6th March 2019 (by email)

Application No. 6/2019/0217/MAJ

Conversion of Northaw House to form 11 apartments (including refurbishment of existing single caretaker's flat) and underground parking area, the Ballroom Wing to form 2 dwellings, the Stable Block to form 1 dwelling, refurbishment of existing dwelling at Oak Cottage, construction of 2 Gate Lodge dwellings, 3 dwellings within the Walled Garden, 7 dwellings within the Settlement Area, refurbishment of the Walled Garden, refurbishment of access routes and reinstatement of old route, provision of hard and soft landscaping, car parking and supporting infrastructure
At Northaw House Coopers Lane Northaw Potters Bar EN6 4NG

SU1 SETTLEMENT UNIT 1  
 GIA: 195 sqm, 2097 sq ft  
 AS: 21  
 OPP:

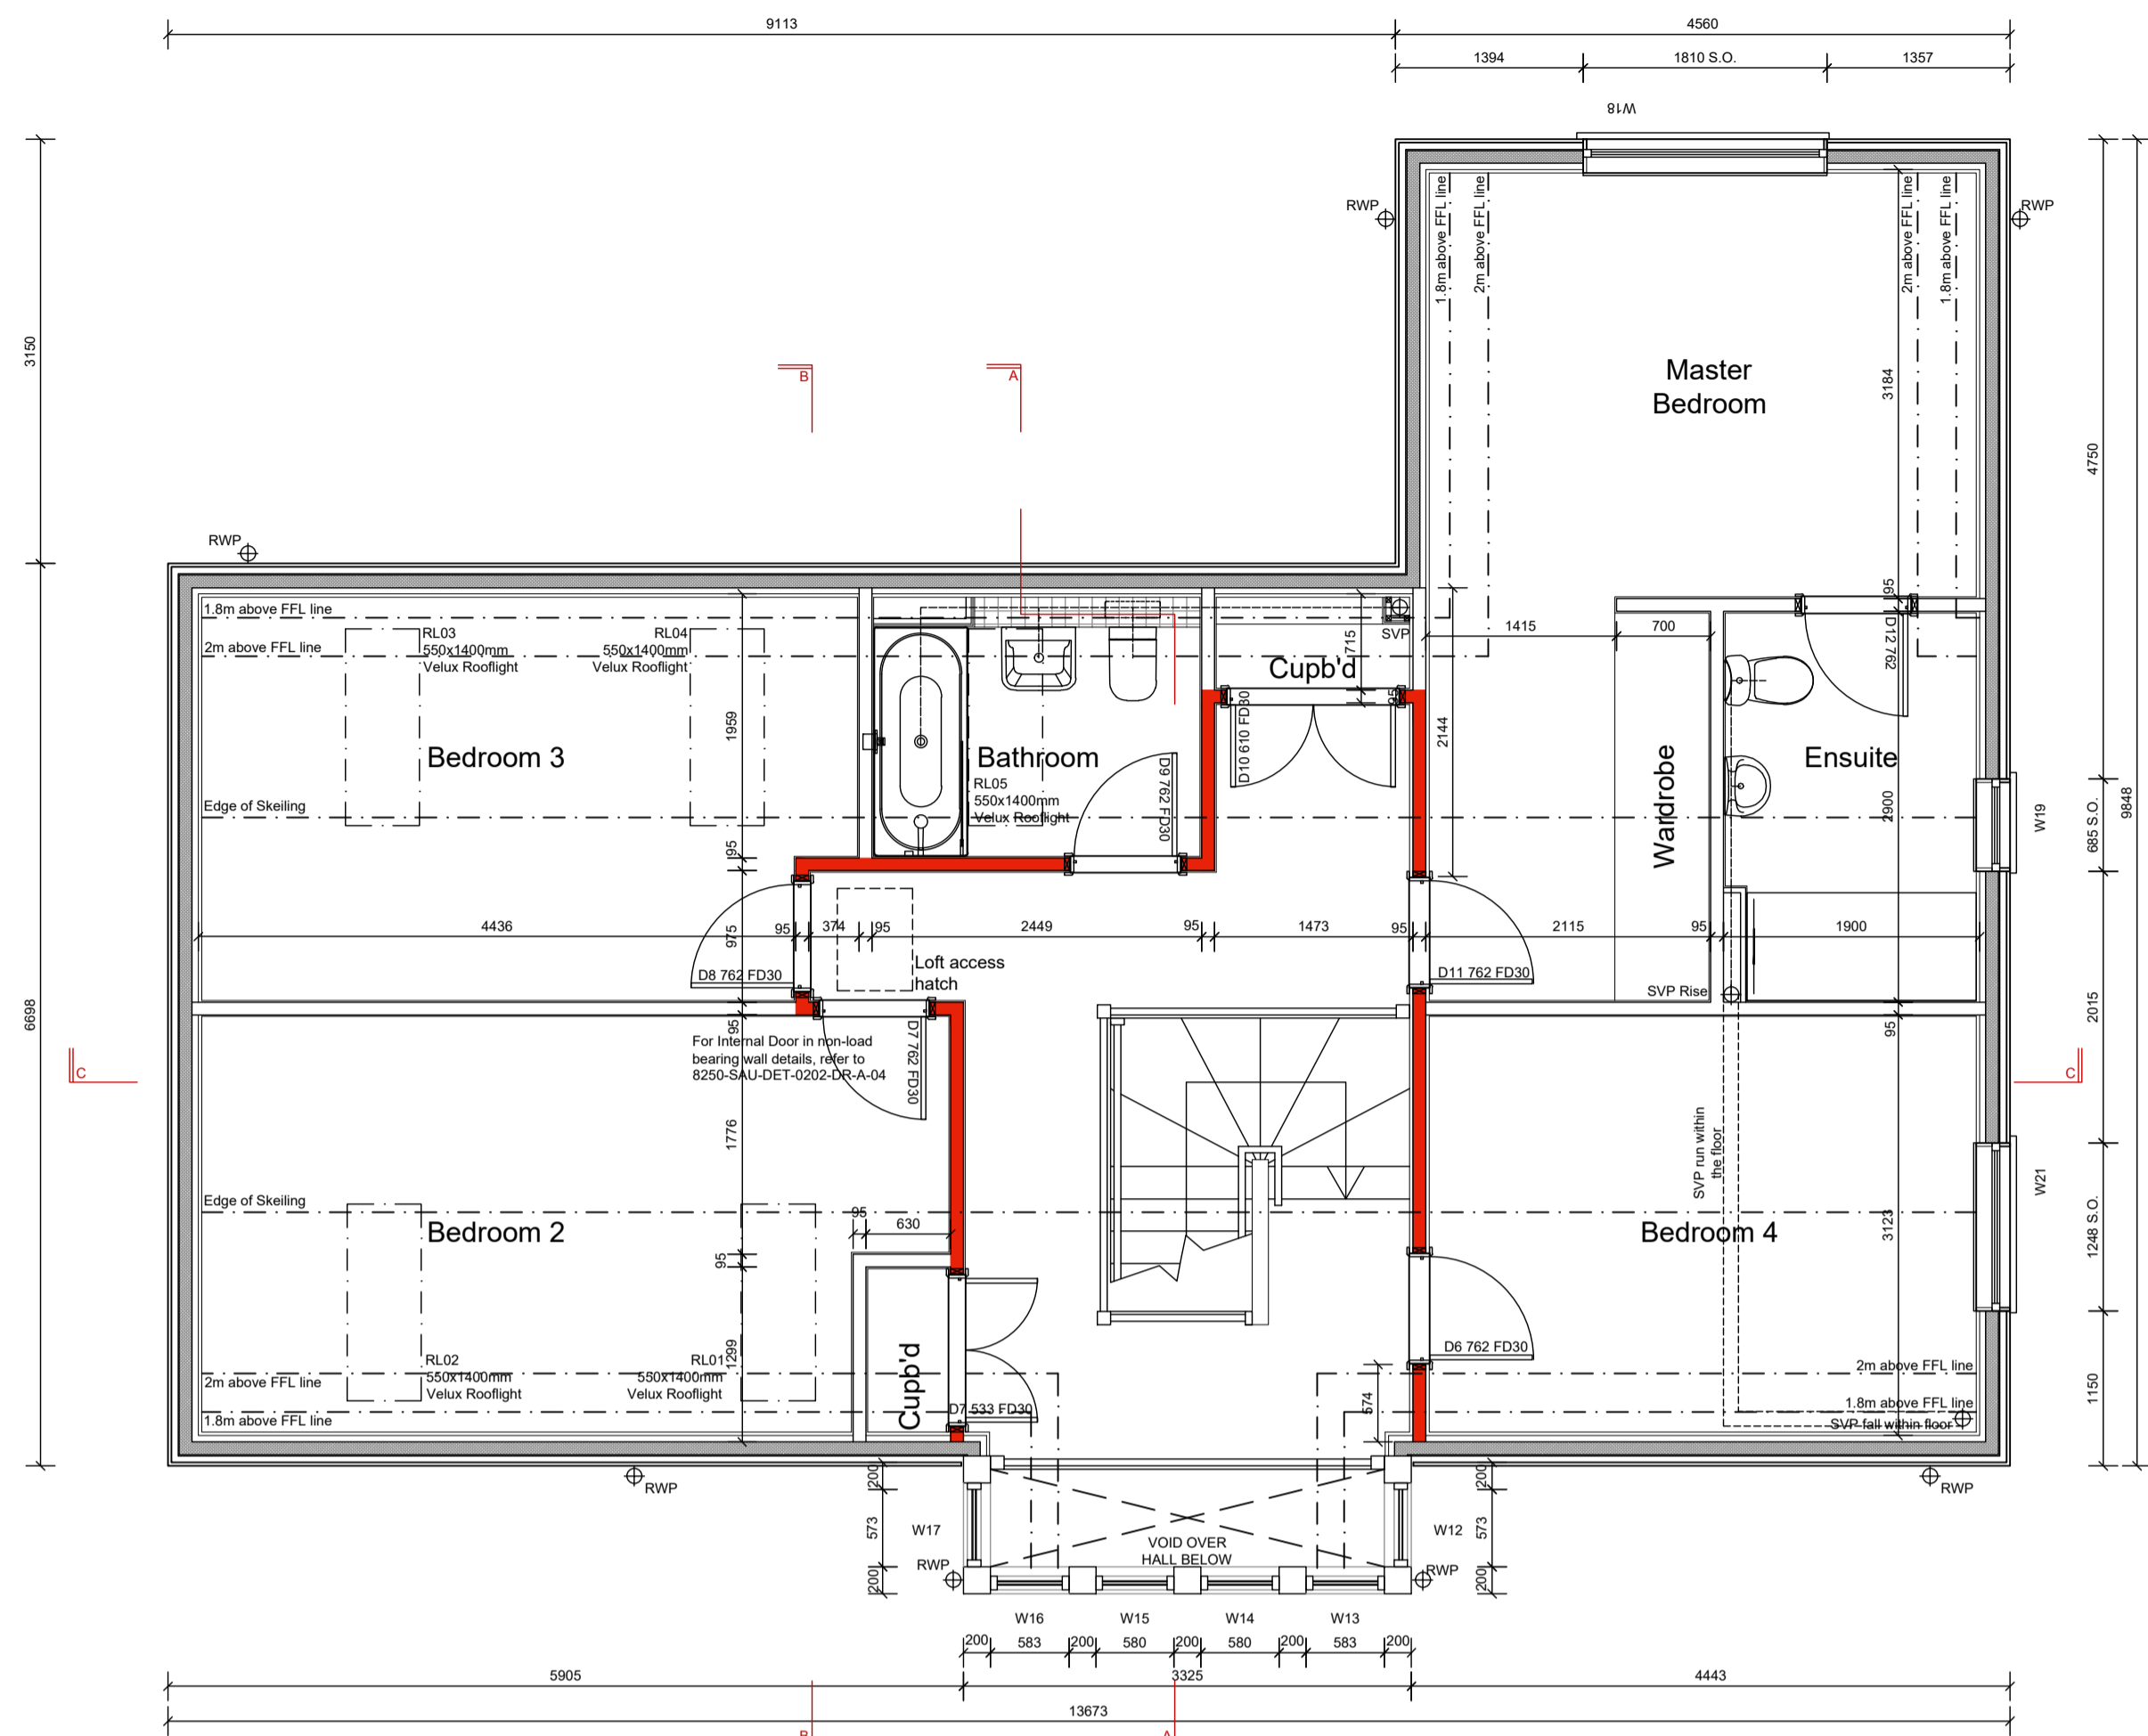
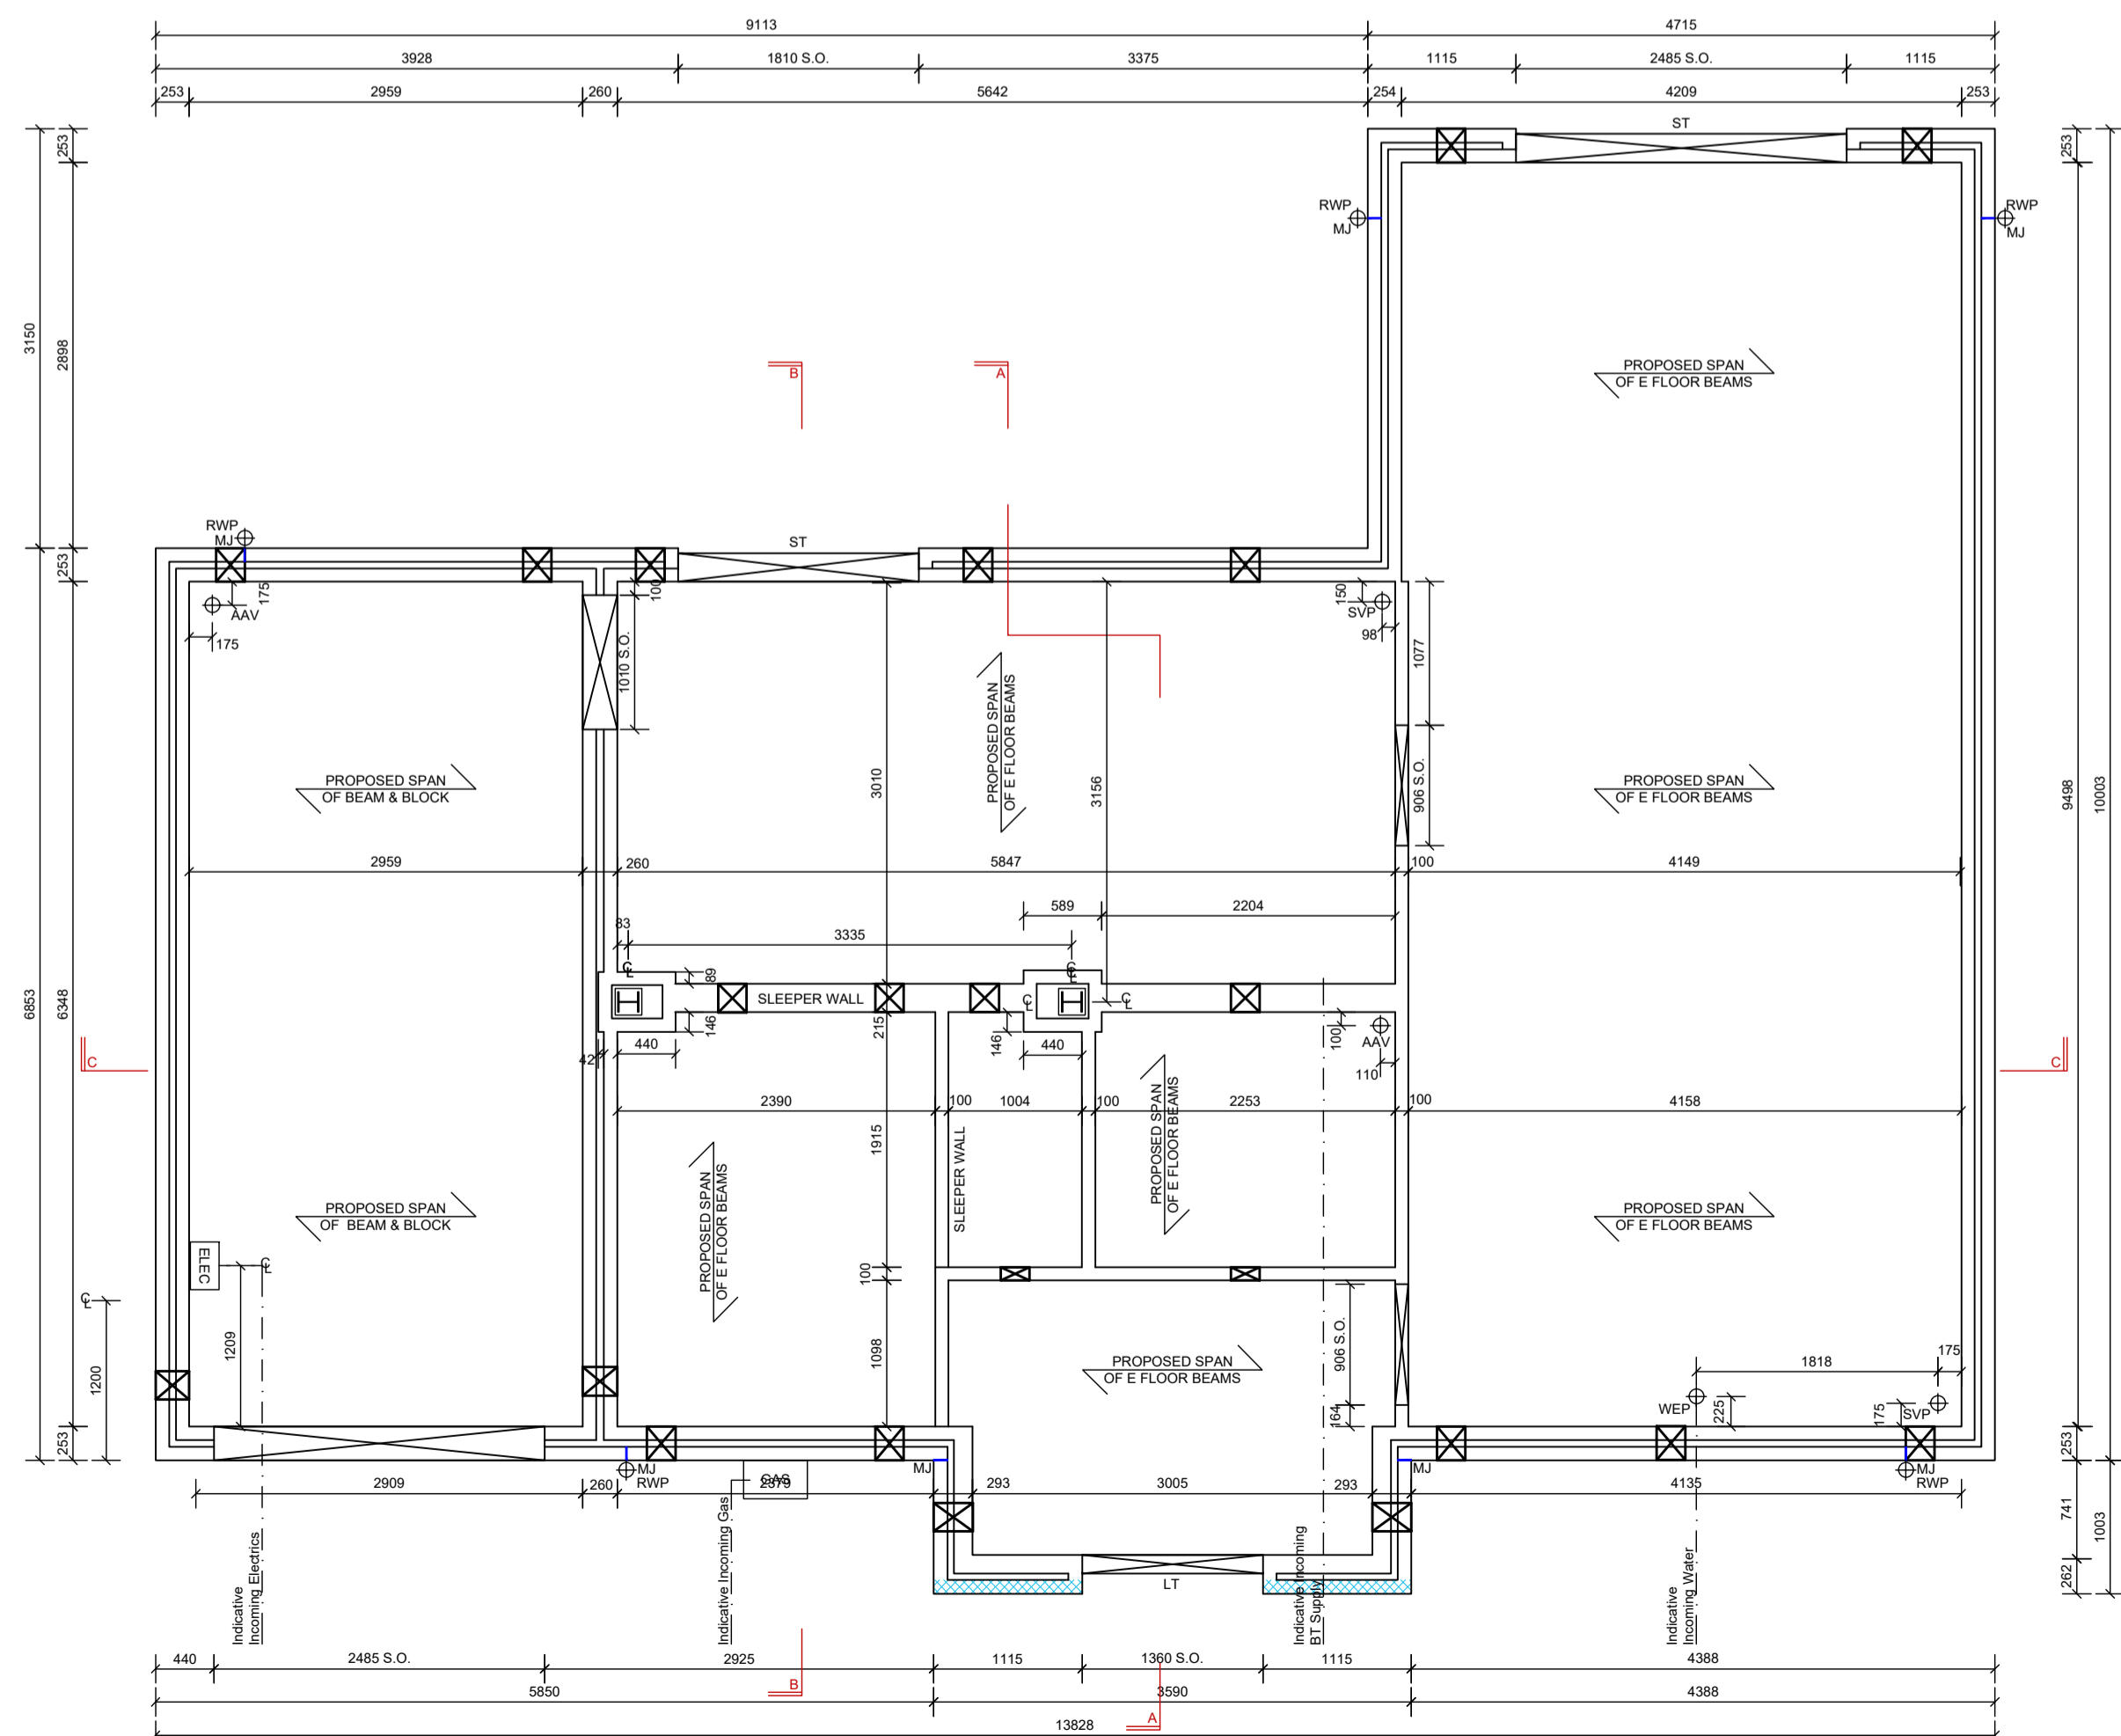
We do not accept the view expressed in para. 84 of the Heritage Statement that the 'settlement units' will effectively appear to be a farm layout providing "a series of high quality agricultural buildings of modern interpretation" which will create "clear visual and physical links to the walled garden." What is proposed is essentially a small cul-de-sac of fairly standard detached and semi-detached housing which has been interposed between the walled garden and the main house. Rather than enhance the links between the heritage assets, it reduces them. Calling the new houses 'The Farm House' and 'The Dairy' etc. does not make them into a farm complex, nor does the layout lend itself to that interpretation.
